Your Ref:
Our Ref: 21/1270/LBC
Date: 15 June 2021

INVALID APPLICATION

PROPOSAL: ERECTION OF REPLACEMENT PORCH (AMENDED DESIGN TO PREVIOUSLY APPROVED 20/0459/LBC)
LOCATION: Auchencairn, Closeburn, Thornhill, DG3 5JU

SCALE	PAPER SIZE	DRAWING NUMBER	REVISION
1:50/1:10@A3		454833 - BW06

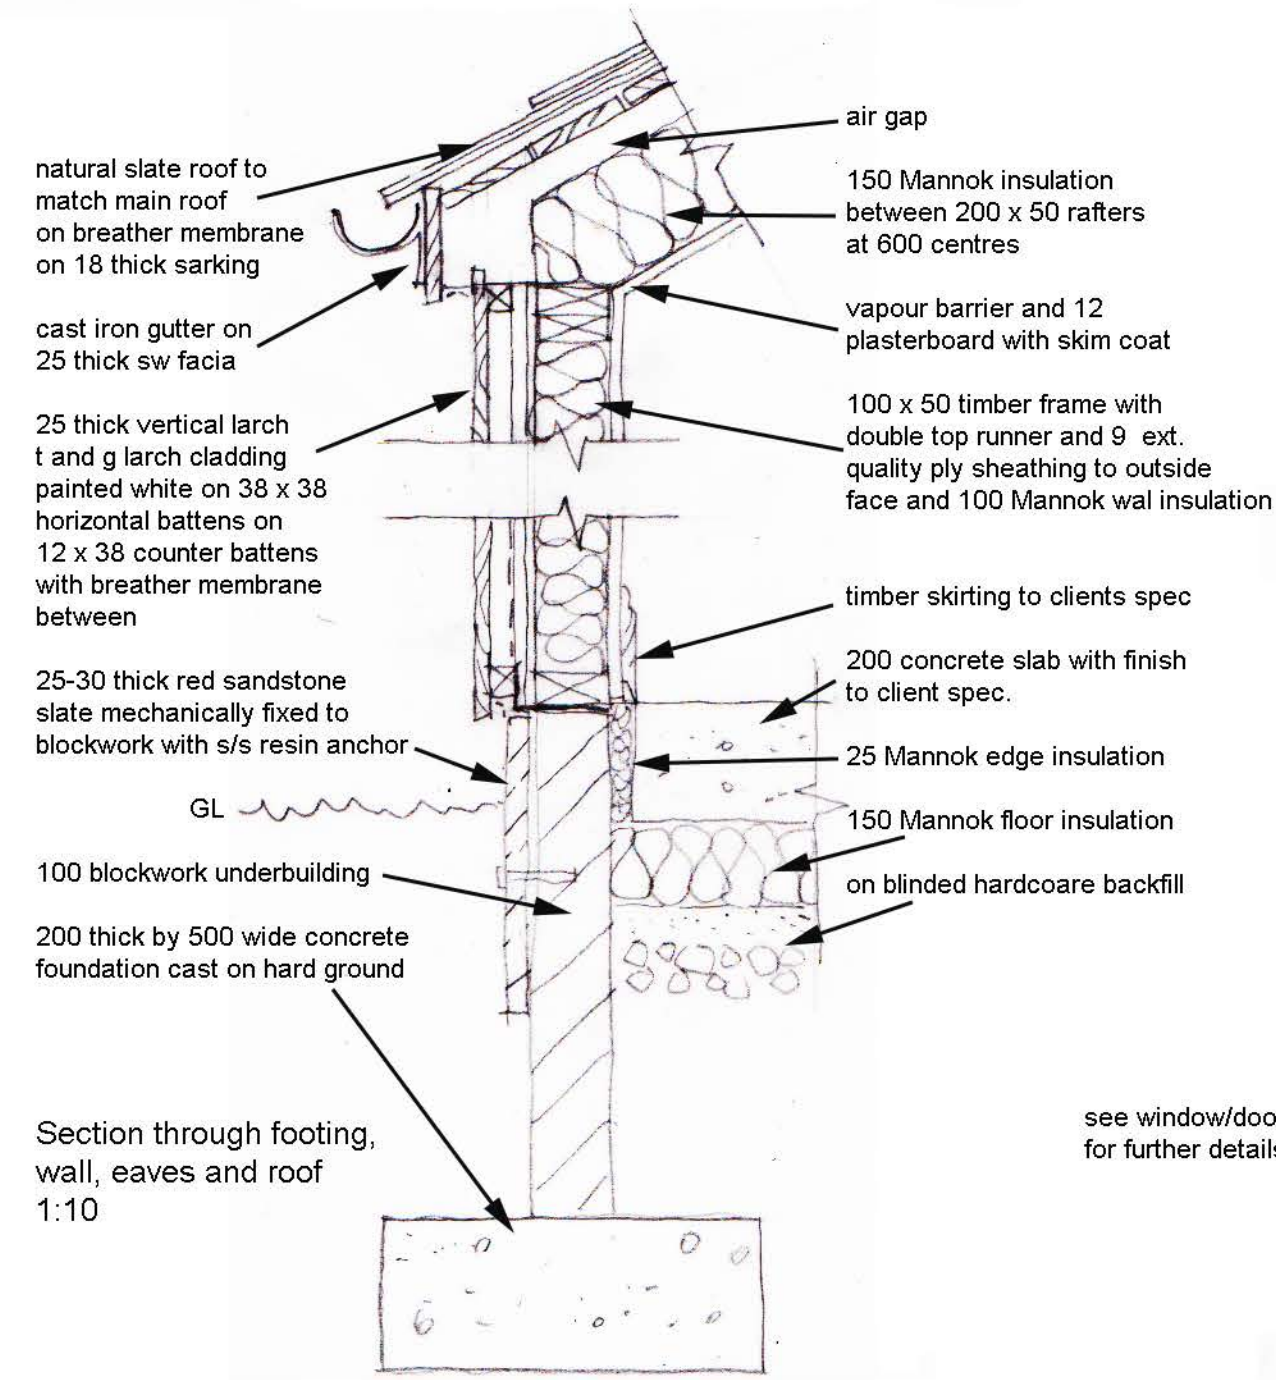
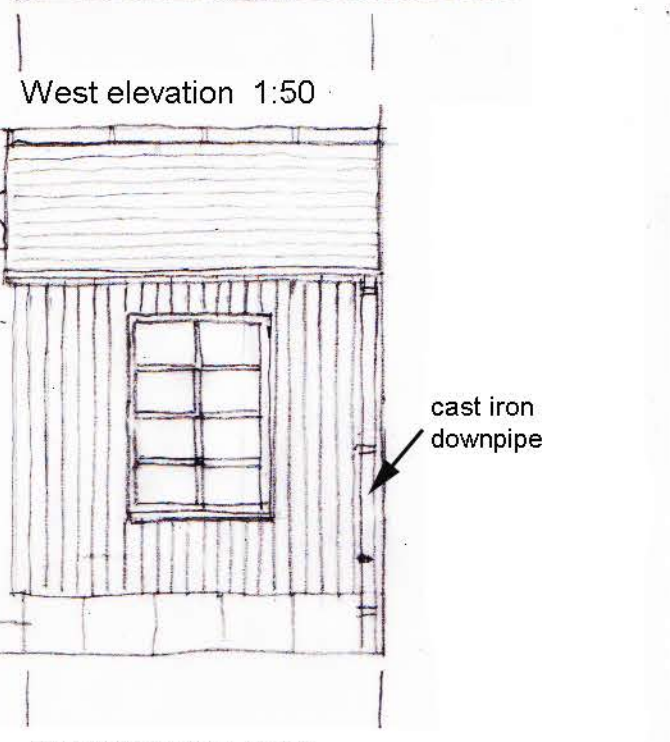
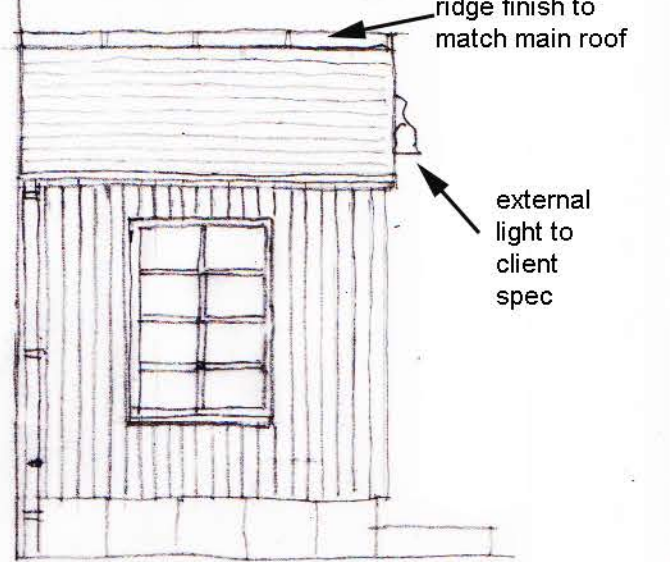
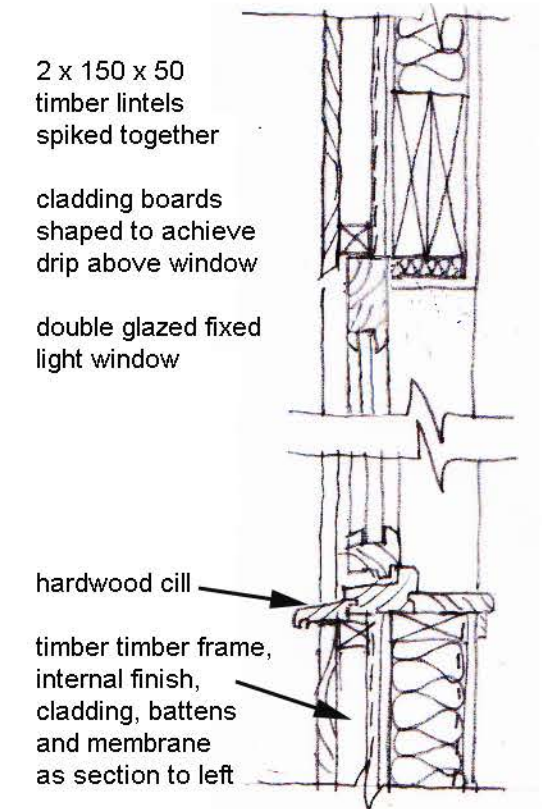
01. The submitted drawing (454833-BW06) showing the porch elevations and cross sections and profiles is labelled differently to the proposed elevations drawing in terms of showing south, west and east. The elevation stating south on the porch elevation drawing should state west. Please arrange to resubmit the porch elevation drawing to notate the correct orientation.
